**Department of Permitting and Inspections**

March 29, 2016

Re: 77 Walnut Street - 012-H-018 – R-6 Residential Zone – proposed conveyance

Exhibit Sketch For Proposed Conveyance

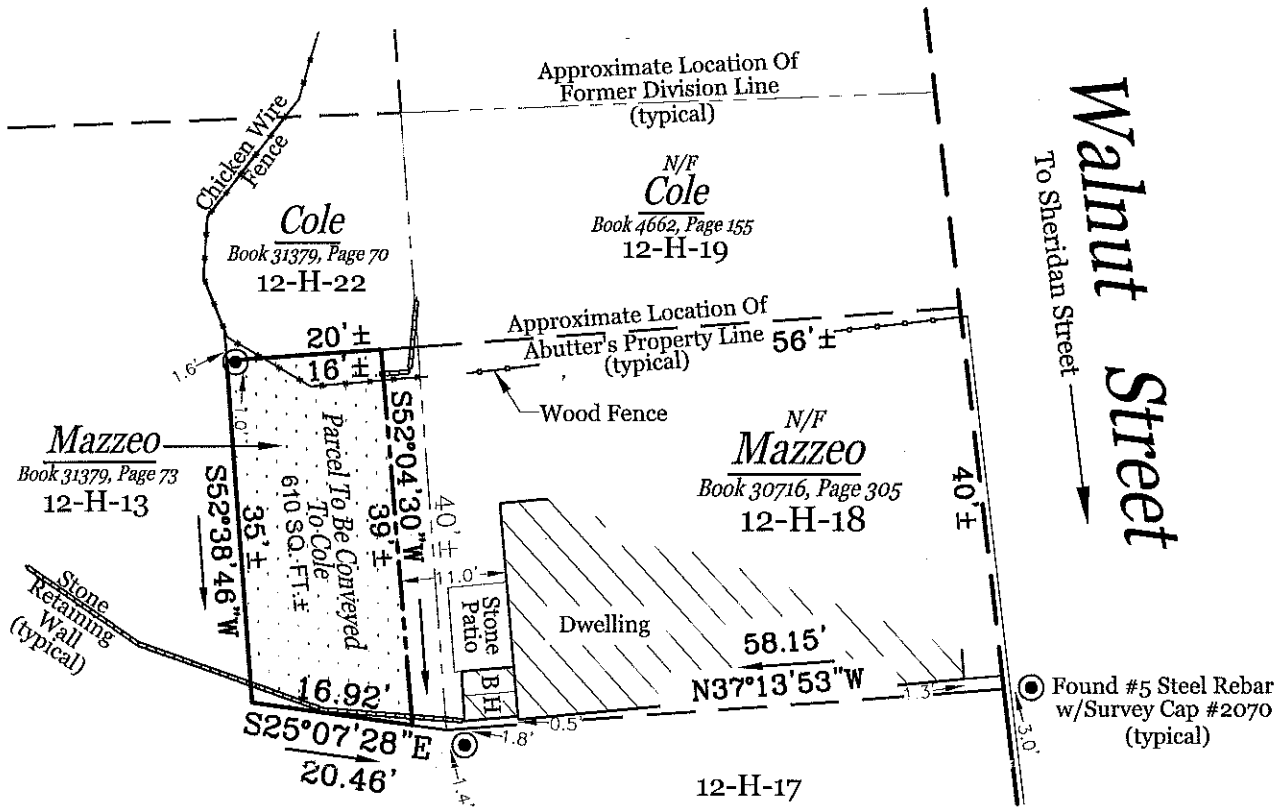
77 Walnut Street is located in the R-6 Residential Zone. § 14-139 of the land use ordinance outlines the dimensional requirements of the zone. The existing lot is 3010 square feet. If the proposed parcel is conveyed, the remaining lot will be 2400 square feet which is in compliance with the minimum required lot size of 2,000 square feet and the minimum land area per dwelling unit requirement of 1,500 square feet for two dwelling units. The Sketch shows the rear setback, if the proposed parcel is conveyed, as eleven feet off the rear of the building, which meets the minimum rear setback of ten feet. There is an existing bulkhead on the rear of the building which extends into the required rear setback. § 14-425 of the ordinance states:

The existing bulkhead extends 5.5 feet off the rear of the building. The footprint is 27.5 feet. As long as the maximum height of the bulkhead is 24 inches or less, the bulkhead does not have to meet the minimum rear setback of ten feet and, the proposed eleven foot setback would be in compliance.

The square footage of the proposed conveyance of land is approximately 610 square feet. This does not meet the minimum lot size for a parcel in the R-6 Residential Zone. This parcel is to be conveyed to the northerly abutter, Deborah Cole, at 71 Walnut Street. Since the proposed conveyance of land does not meet the minimum lot size or have any frontage on a city street, this land will merge with the existing land at 71 Walnut Street, and be considered one lot.

As shown on the Sketch, the proposed conveyance of land from 77 Walnut Street to 71 Walnut Street is in compliance with the City of Portland Land Use Ordinance.
